21st February 2015

Planning Application Ref: R/15/15/PL
1 Merton Avenue, Rustington, West Sussex
Proposed installation of 2 velux style windows to east and west roof elevations

proposed side elevation (East)

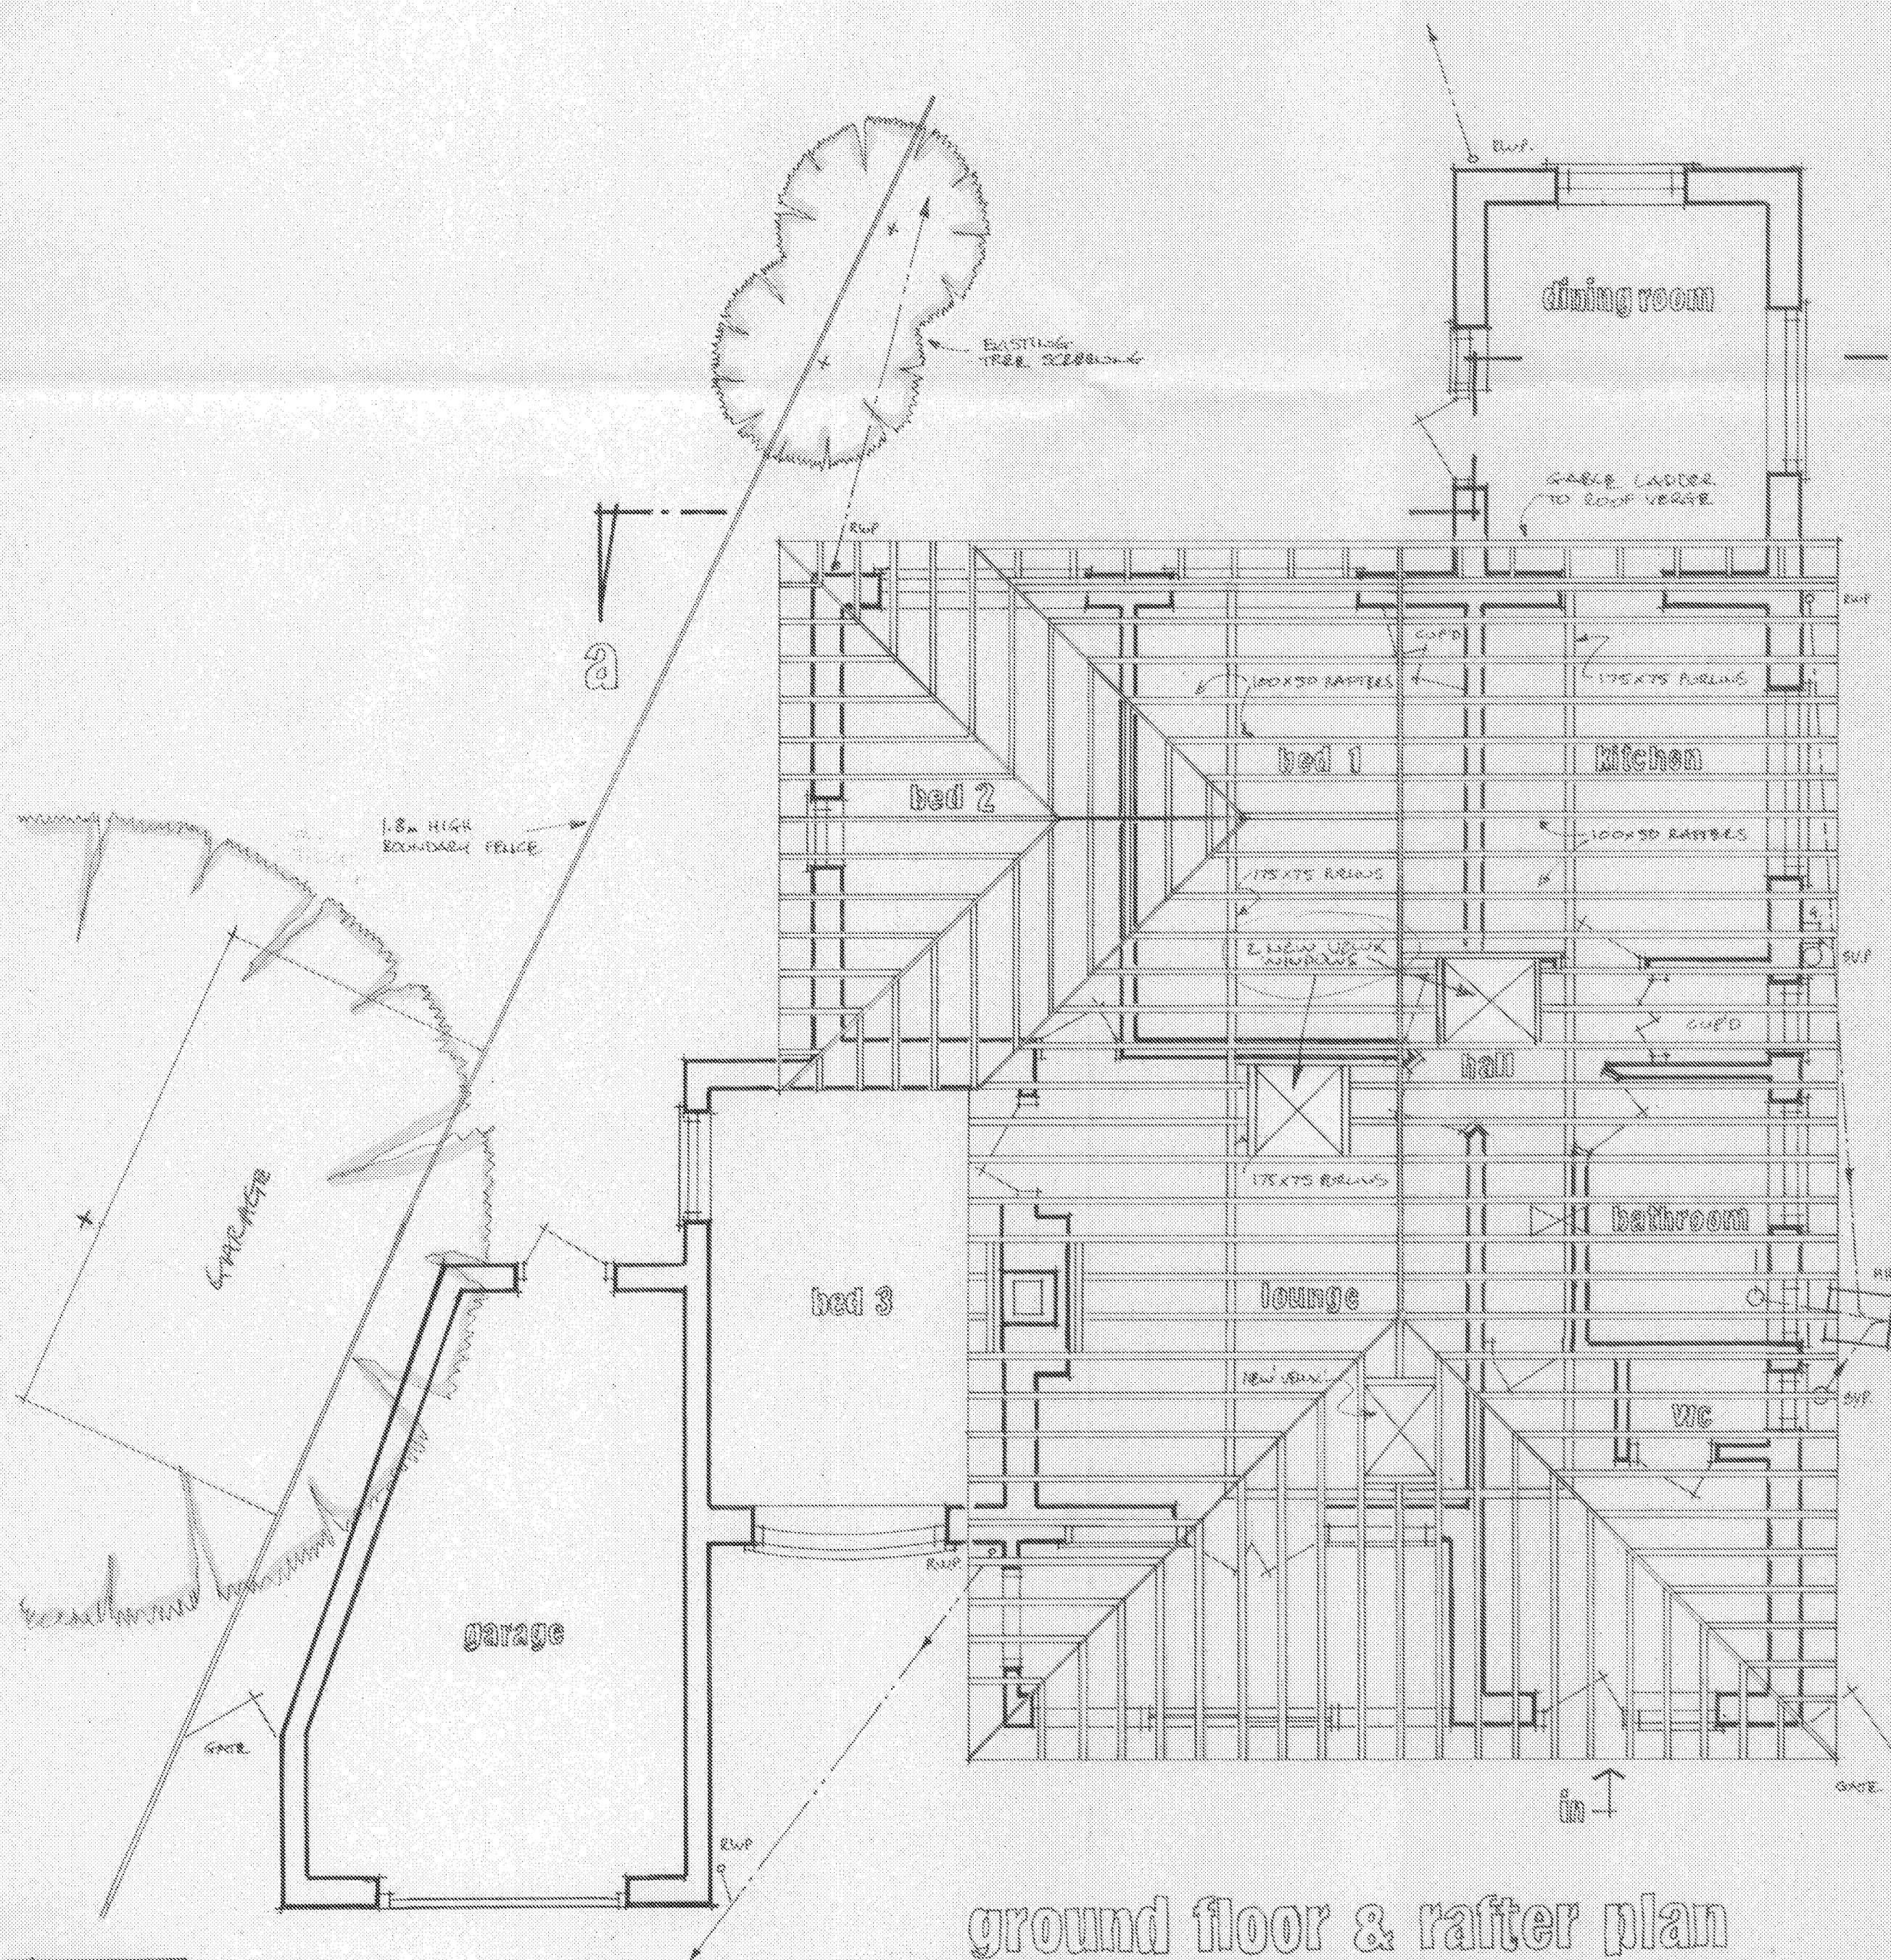
I would like it duly recorded that I object strongly to the installation of the east window directly facing our property, 3 Merton Avenue.

- 1) The installation of any window on the east side, particularly of the size proposed, would have a direct line of sight into the windows of our home and down our garden, which I consider to be an infringement of our privacy rights. Their property is only a few feet away from our bungalow and this is unacceptably invasive and intrusive and will make us vulnerable.

1) I do not believe this is in keeping with the surrounding area and current buildings. Any permission would therefore set a precedent and would cause undue distress to the surrounding neighbourhood. The proposed velux windows are considerably larger than the existing front velux window and therefore would further differentiate No. 1 from Nos. 3 and 5 Merton Avenue and adversely affect the street scene.

(WEST) SIDE ELEVATION - PROPOSED

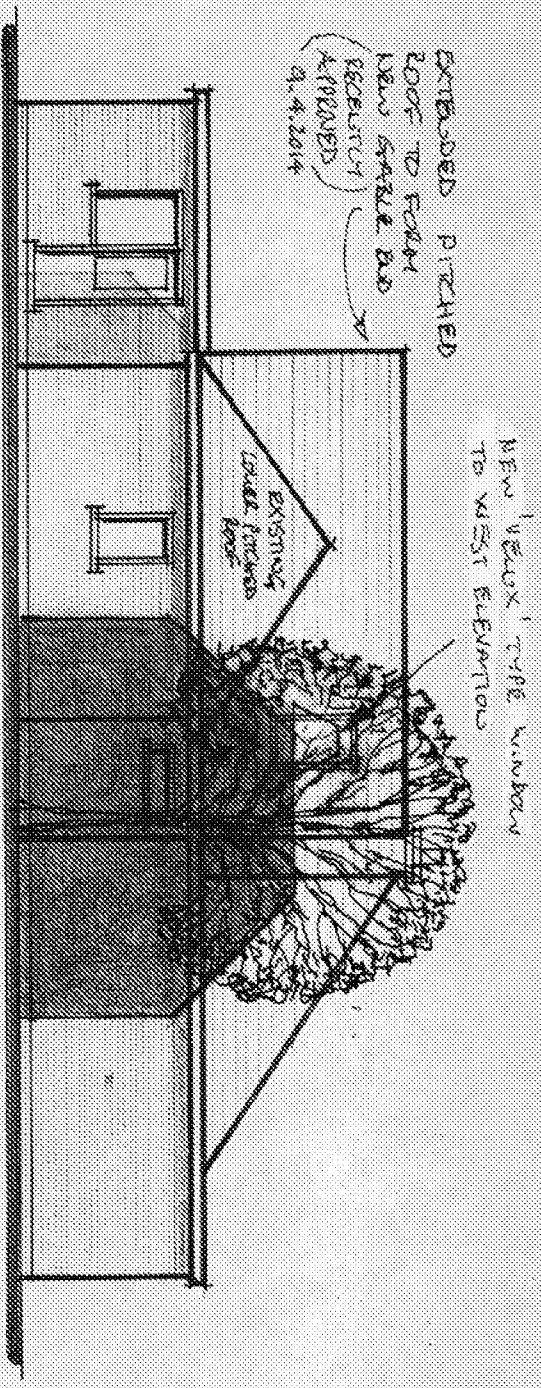
- 3) A specific drawing has been presented of the view from the west side alleging that the properties to this side will be offered some form of screening by the magnolia tree, lower pitched roof, and a garage. No such "protection" is afforded to our property.
